Our Reference: SYD17/01576/02 (A21586344)
Department Ref: SSD 8894

**ST LEONARDS HOSPITAL – TOWER B – DETAILED DESIGN AND CONSTRUCTION
12 FREDERICK STREET, ST LEONARDS**

Reference is made to the Department's letter dated 26 February 2018, regarding the abovementioned Application which was referred to Roads and Maritime Services (Roads and Maritime) for comment in accordance with the *State Environmental Planning Policy (Infrastructure) 2007*.

**Figure 5.4: Potential Herbert Street/ Westbourne Street with Roundabout Control**

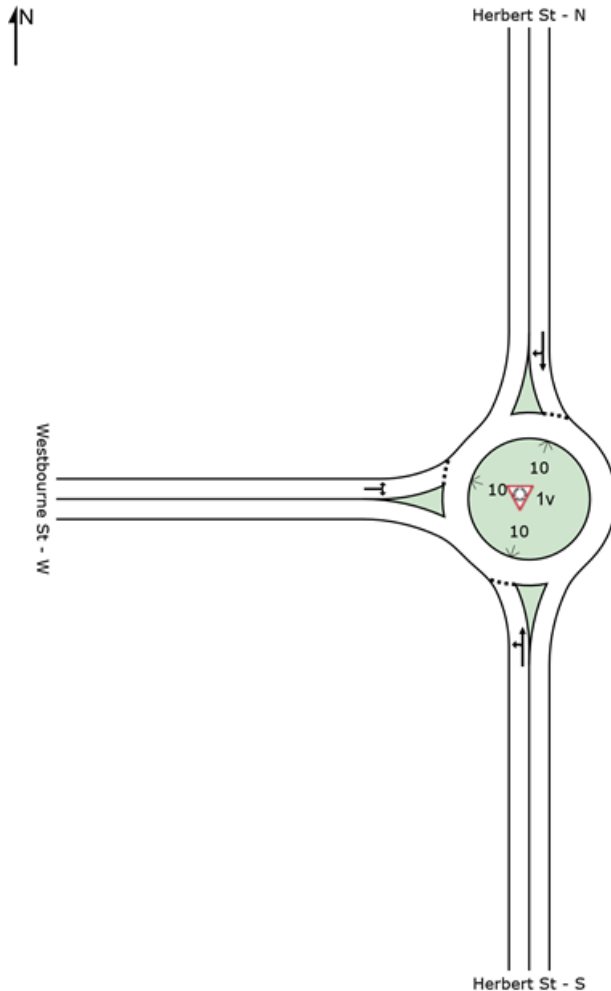
4. The proposed roundabout at Westbourne Street and Herbert Street proposes to merge cyclists with traffic on Herbert Street as opposed to the existing continuous cycle lanes and it is a safety concern. Roads and Maritime requests to design the subject roundabout as per Roads and

Maritime's "*NSW Bicycle Guidelines*" which would include appropriate signs and delineation to ensure cyclists safety.
